July 29, 2022
File No. 20-174.300

**Subject: Response to Geotechnical Review Comments
Proposed SFR
4006 E Mercer Way, Mercer Island, WA
#2010-070-SUB1**

**EXCAVATION PLAN**  
SCALE: 1/8" 1'-0"

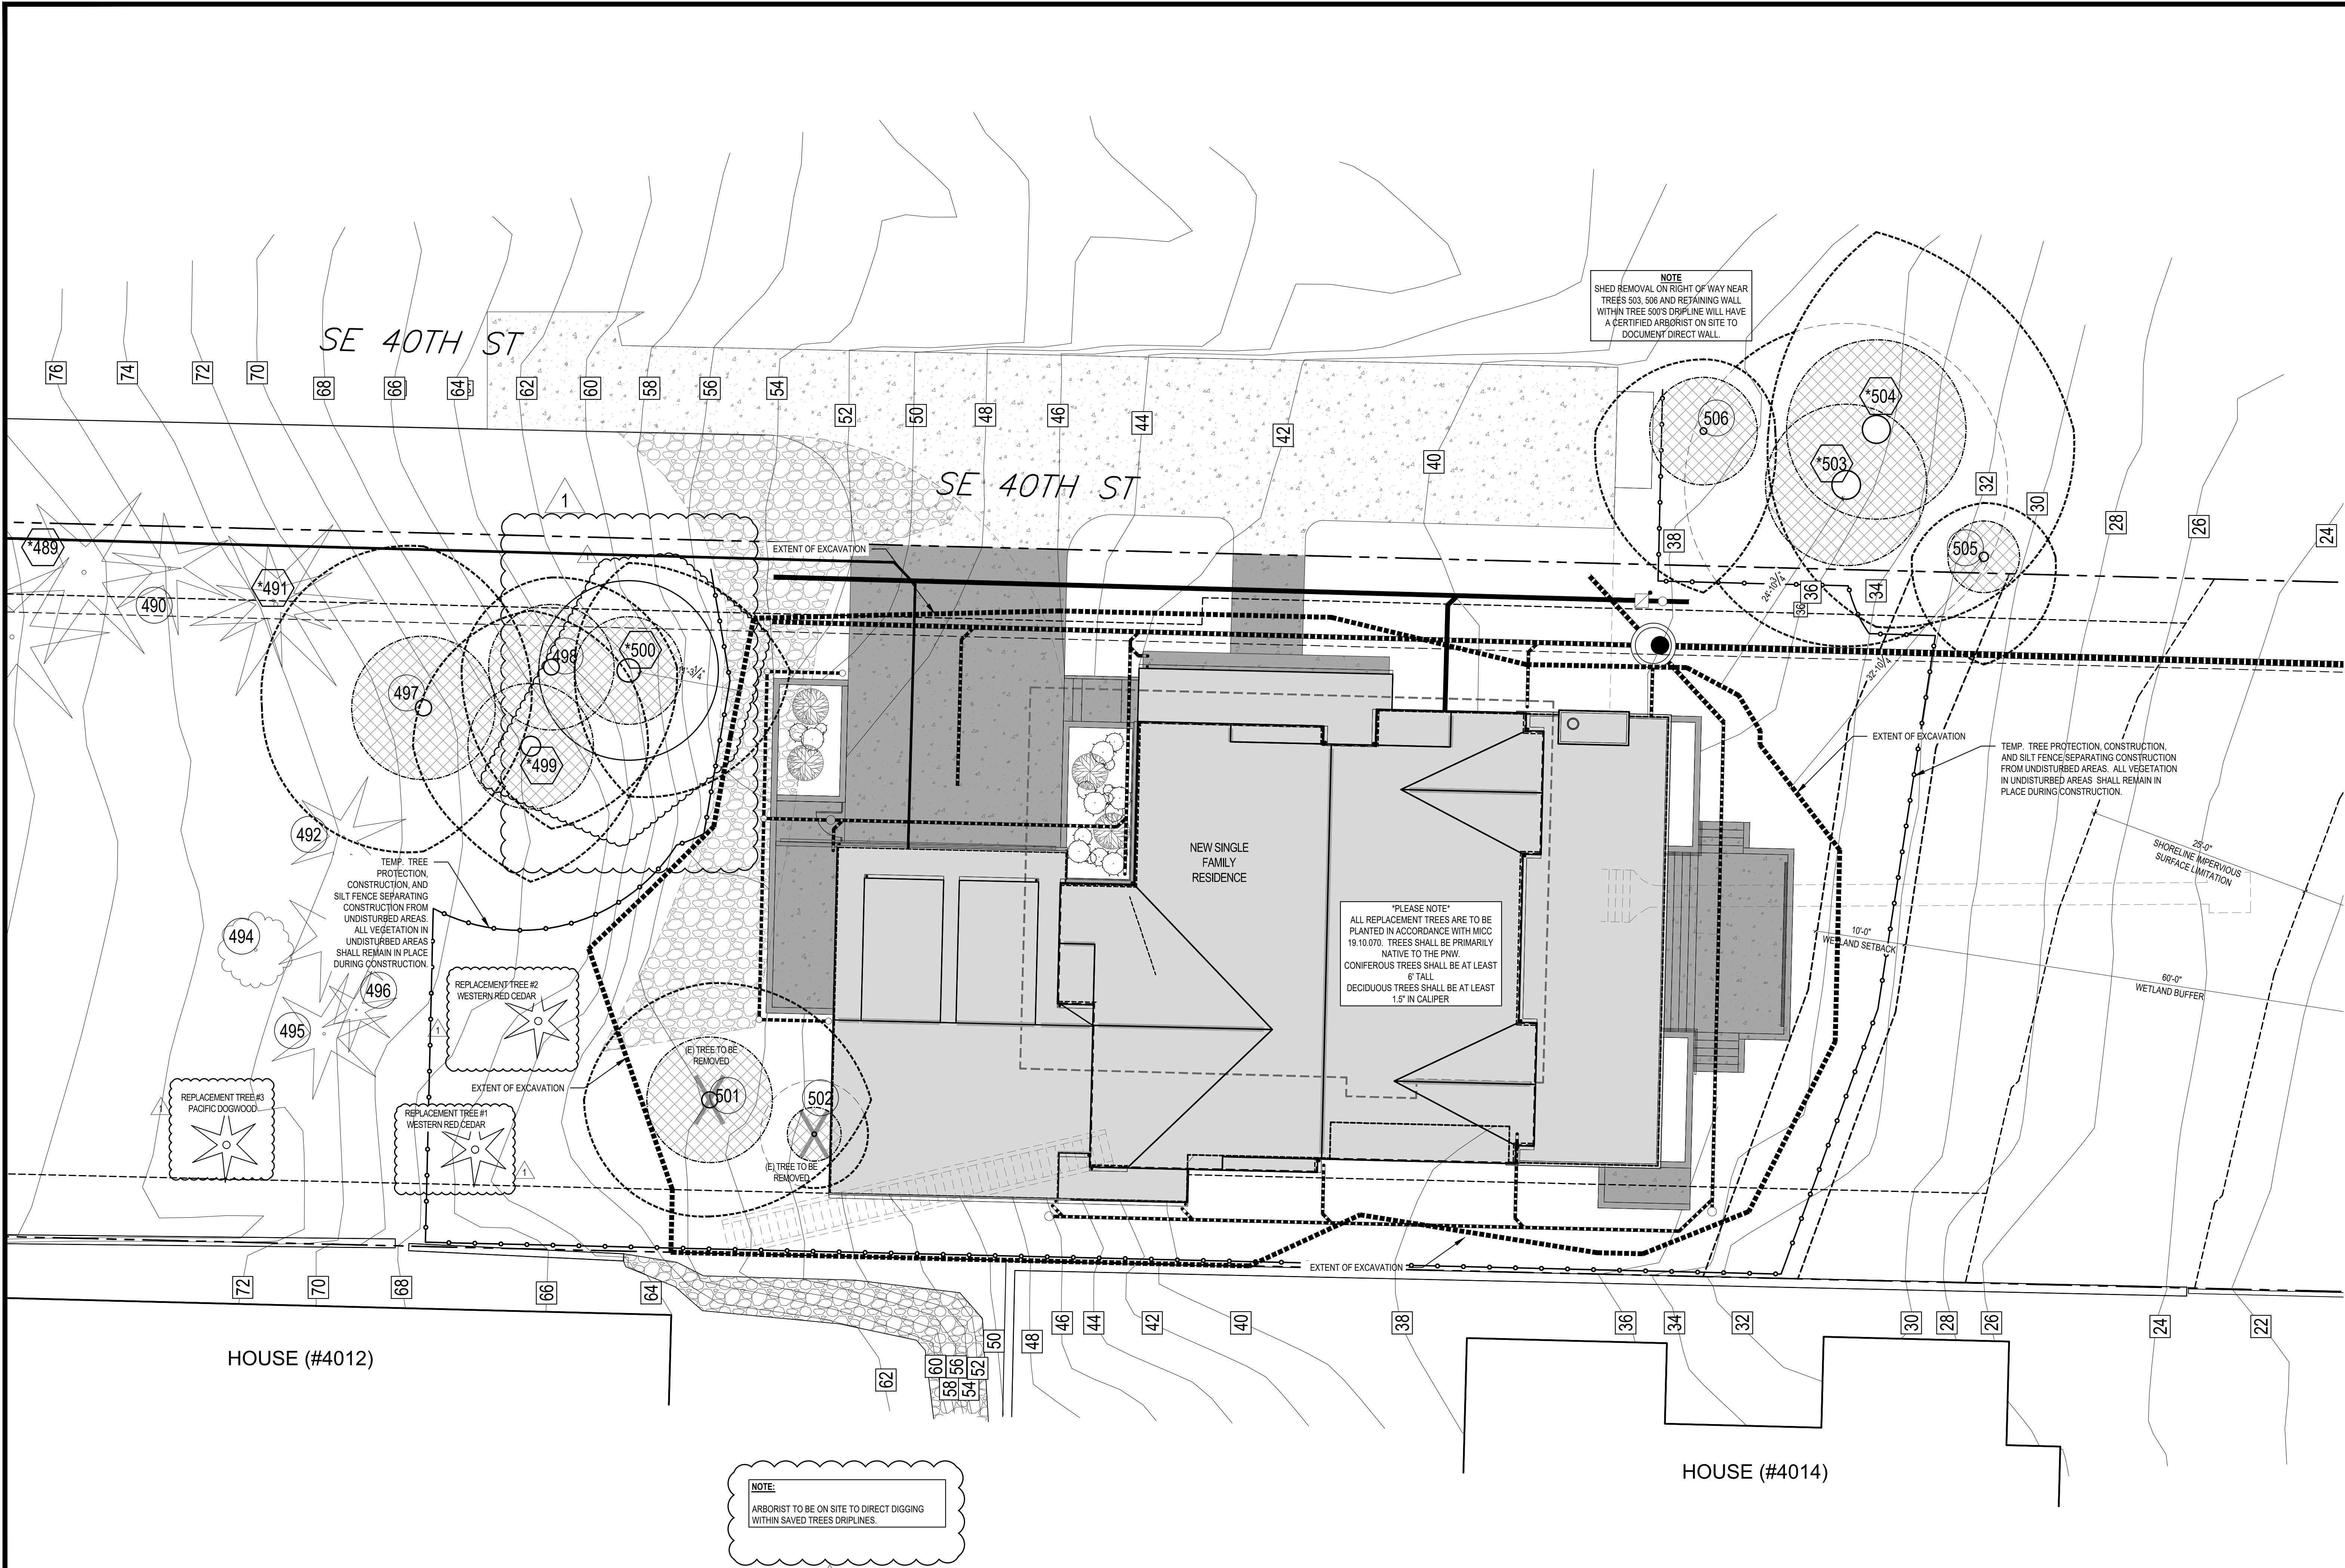
Comment: After revising the extent of excavation, geotechnical engineer to verify that the excavation does not undermine what appears to be a structural feature along the south property line.

If potential conflicts along the south property line are anticipated, provide potential solutions or recommendations for temporary shoring, etc. Provide these recommendations in a letter report.

Comments: Geotechnical engineer to provide discussion of the anticipated stability of temporary 1H:1V and proposed vertical cuts in a letter report. Current report indicates anticipated cuts of 5 feet. This excavation plan shows cuts significantly greater than that. It also indicates use of a vertical cut section as shown in section 3/A1.2.

Response: Based on the design, there is sufficient space for 1H:1V open cuts, and the temporary excavations will not undermine the footings of the adjacent south building.

Response: Based on the dense glacial till encountered at the surface in PG-3 at this location, it is our opinion that the temporary excavations using 1H:1V combined with a 4-foot vertical cut is feasible in this small section.
